Harnett County Government Complex  
307 Cornelius Harnett Boulevard  
Lillington, NC 27546

**RE: Status of Existing Tank Permit Application #05-5-12793  
#05-5-12792**

OPERATIONS PERMIT

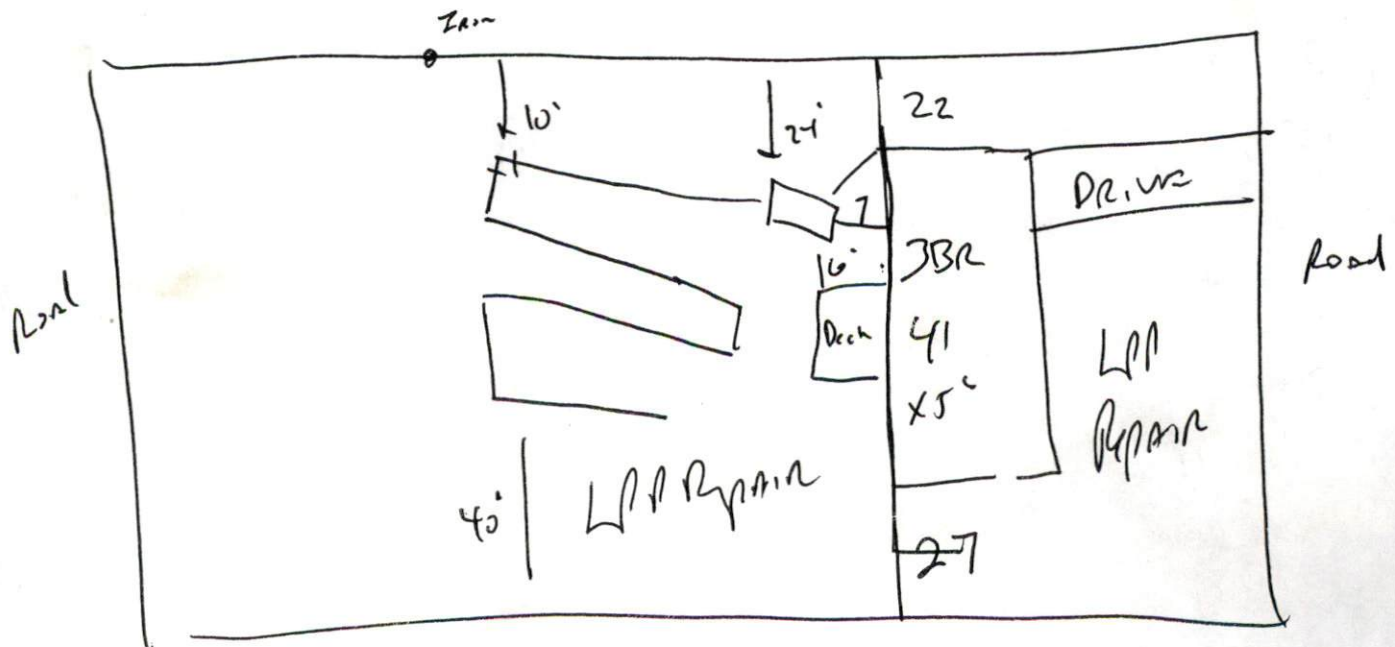
- 1. Uncover outlet lid on septic tank and break seal
- 2. Have system pumped out
- 3. Replace sanitary T
- 4. Other ***Go to Central Permitting and fill out application for soil evaluation. As of now pool is too close to existing drain line. Our 1<sup>st</sup> priority is to correct that situation since pool is up. Once we have that situation figured out, then we will work on additional bedrooms to the home. You will need to reconfirm through the IVR system at the number listed below when ready.***
